Our Ref: LU/177/21/NMA

Non-material amendment following the grant of LU/265/19/PL to change small area of hardstanding to soft landscaping on Western part of site to align with drainage strategy & minor changes to position of external downpipe.

Land at Lineside Industrial Estate Northwest of Unit 26 Eldon Way Littlehampton BN17 5LF

Drawing No.	Rev.
19005 - TP - 004	A

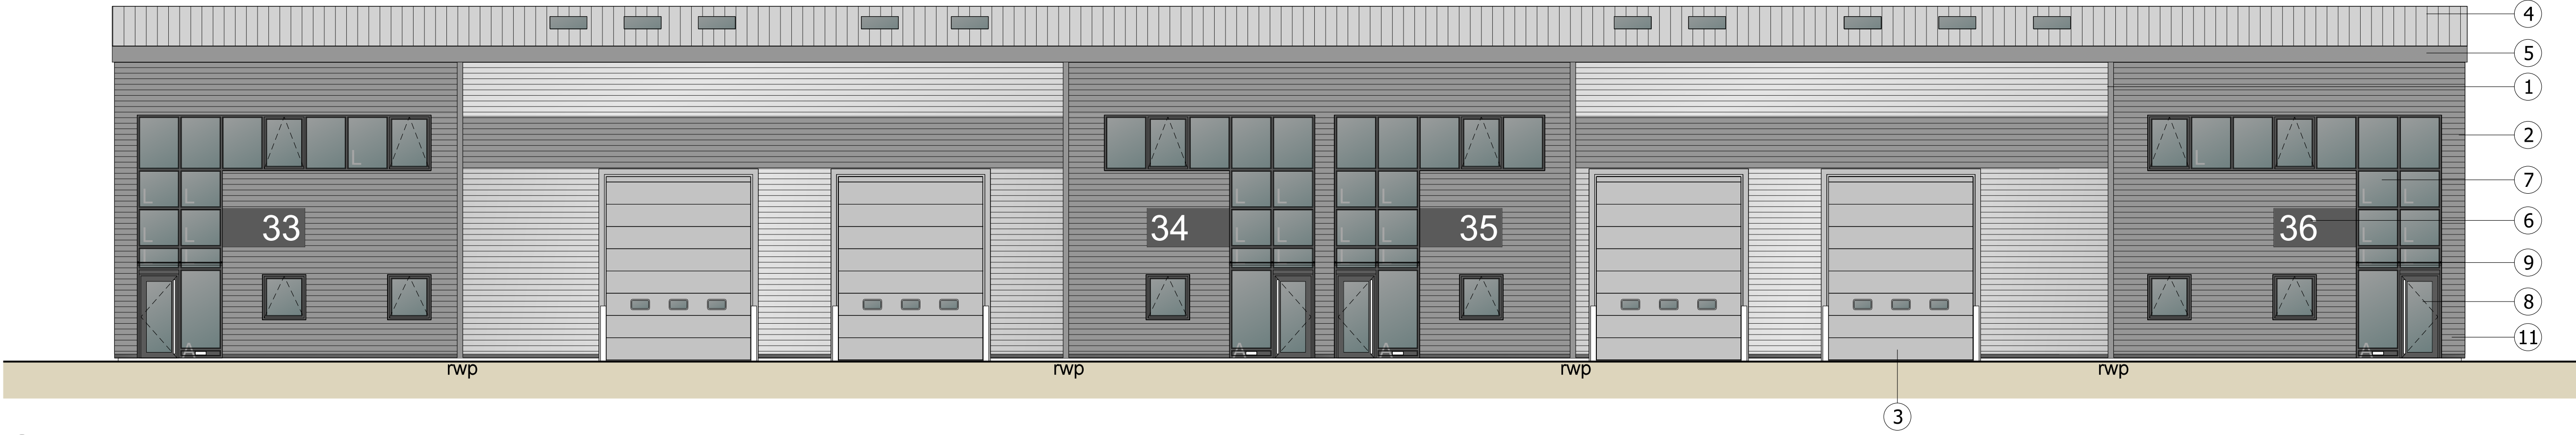
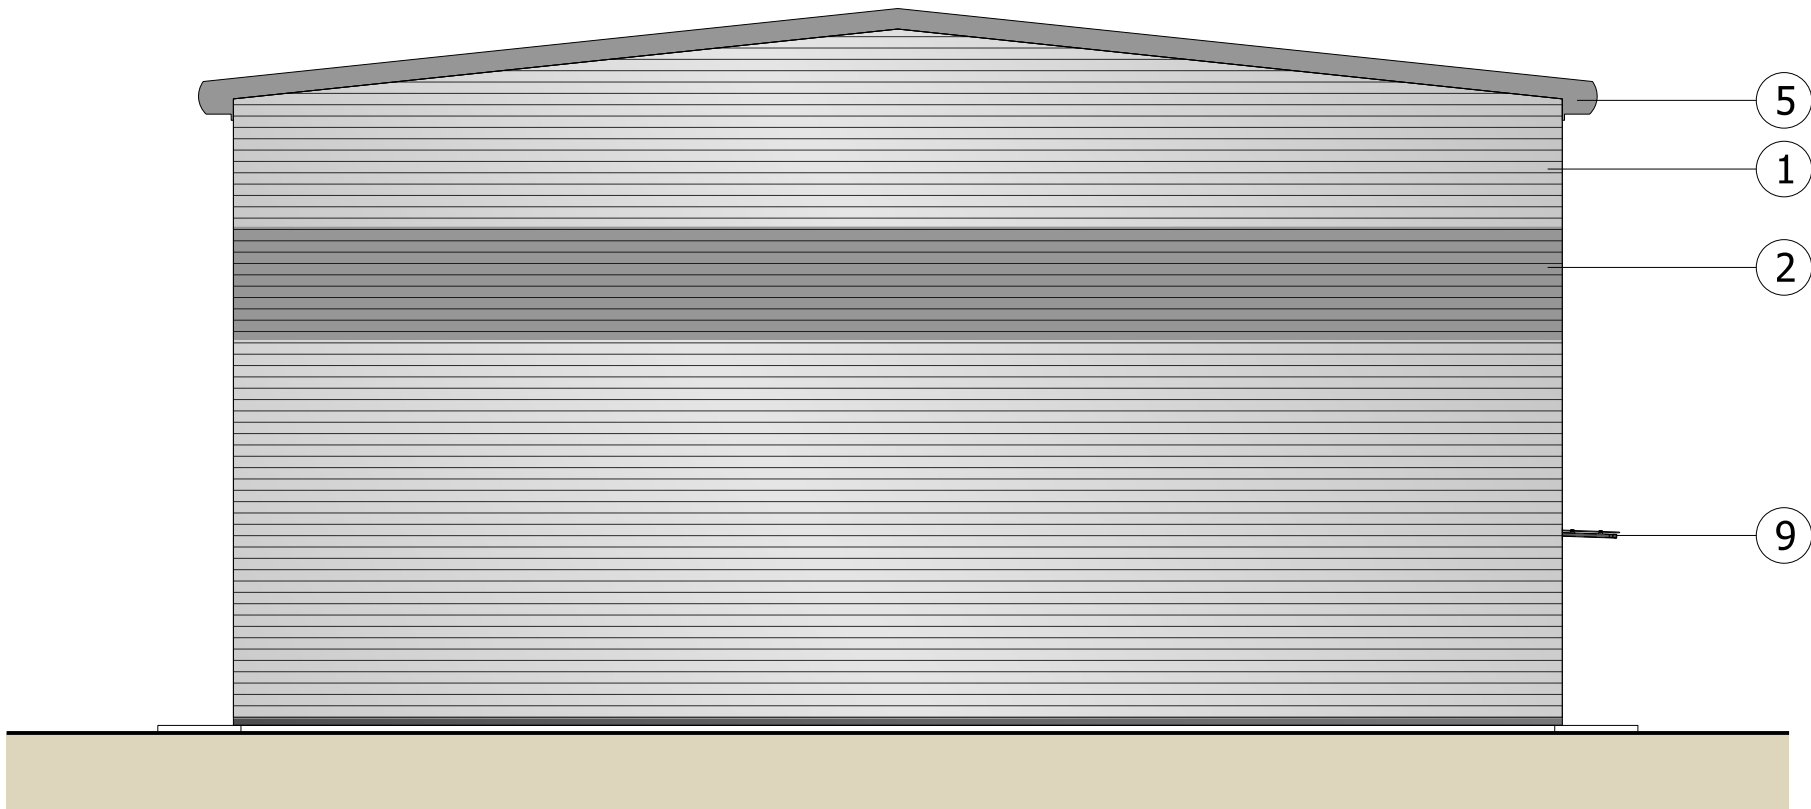
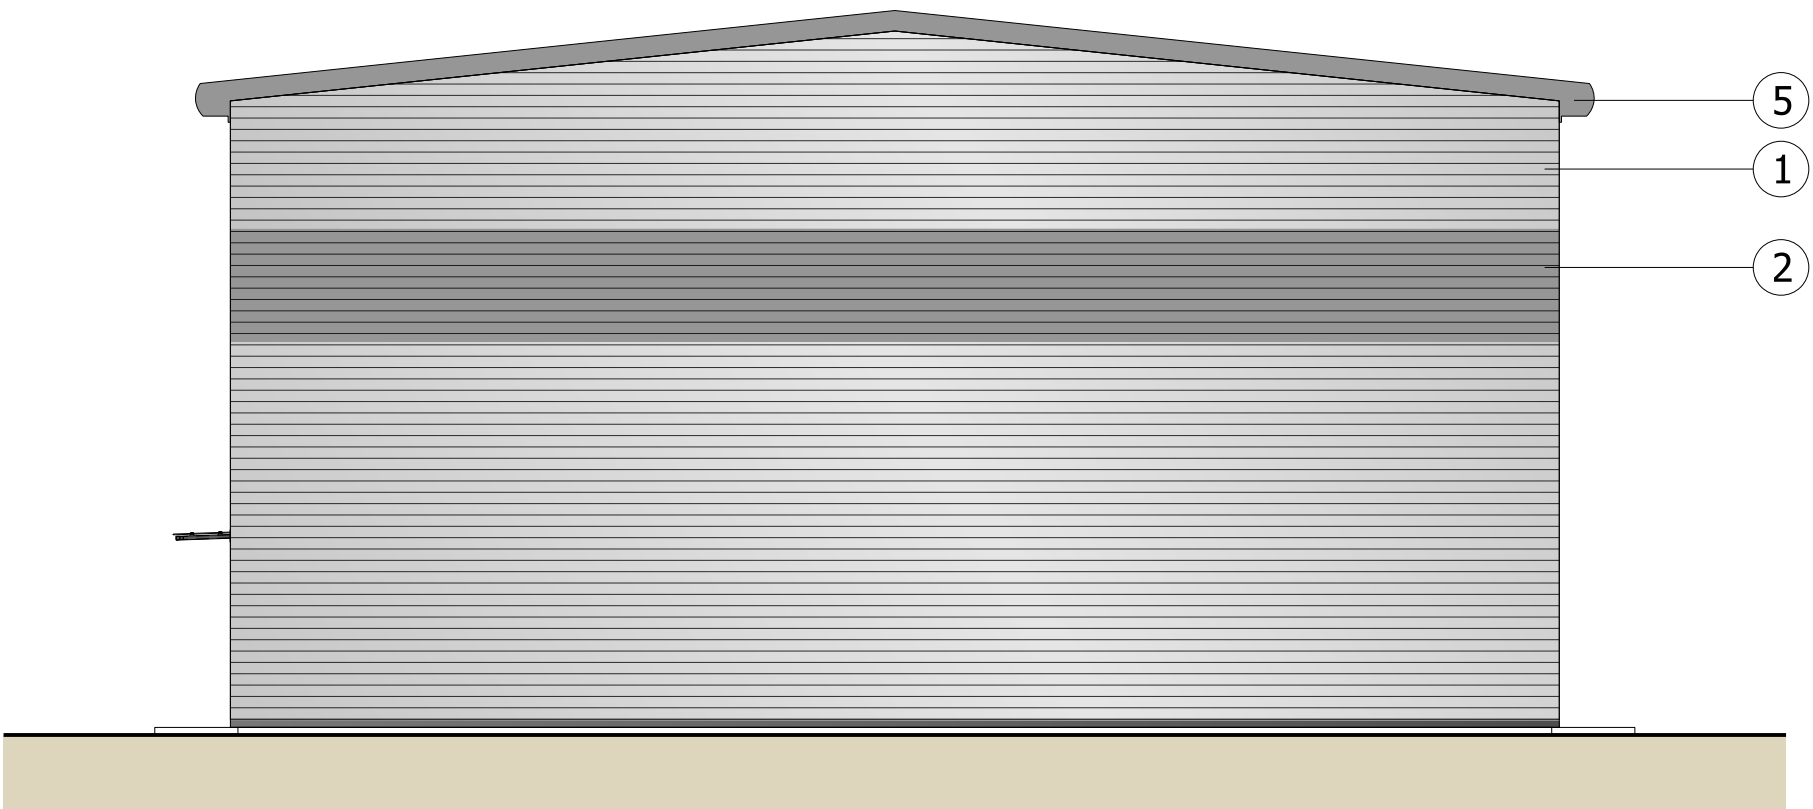
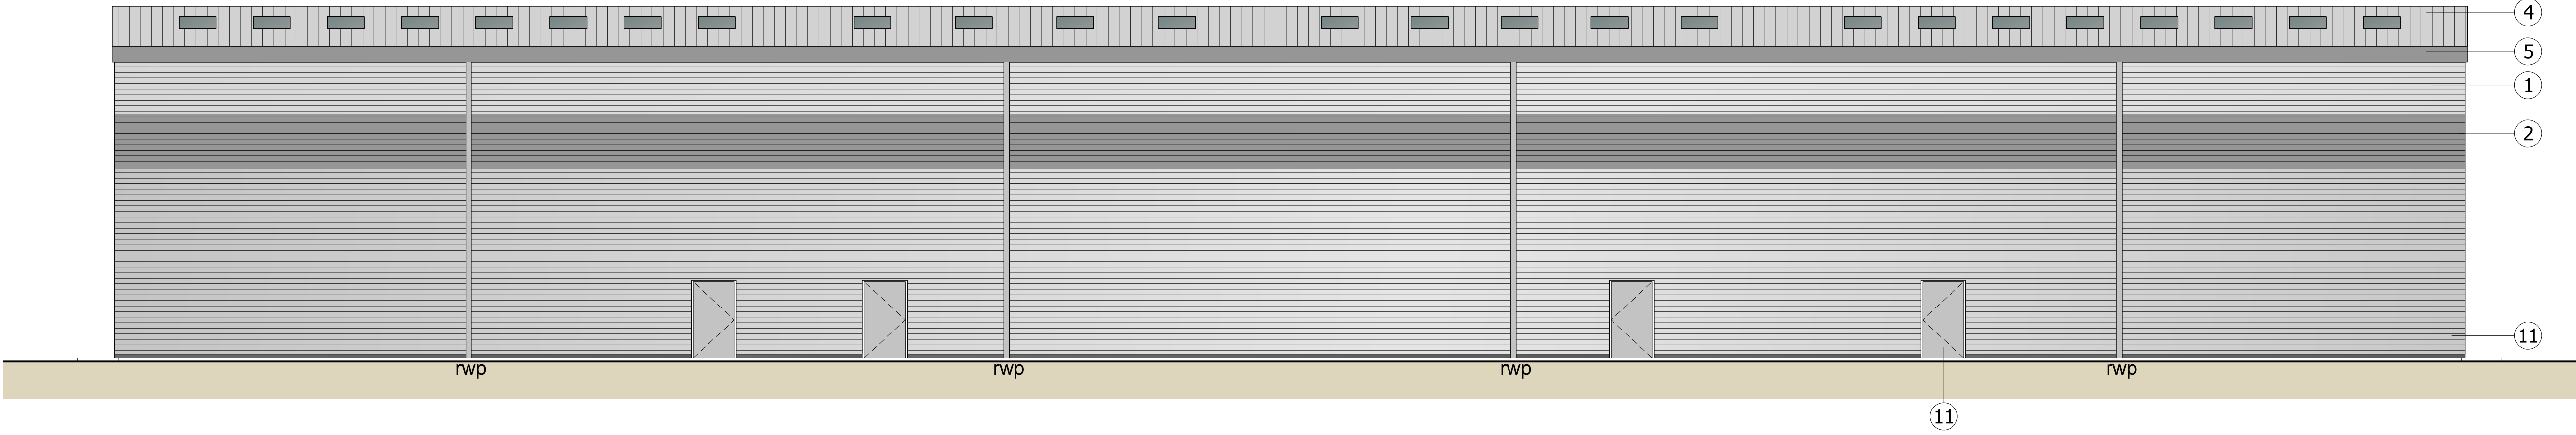
Very minor changes are also proposed to the position of the downpipe so that it can be correctly

integrated with the cladding that has been used. This is shown in the updated Elevations drawing 19005-TP-004 Rev A which would supersede the approved drawing 19005-TP-004.

From the information submitted proposed elevation drawing no: 19005-TP-004 Rev A and proposed proposed site plan 19005-TP-002 Rev B have now become the approved

elevations and site plan for the planning permission LU/265/19/PL.
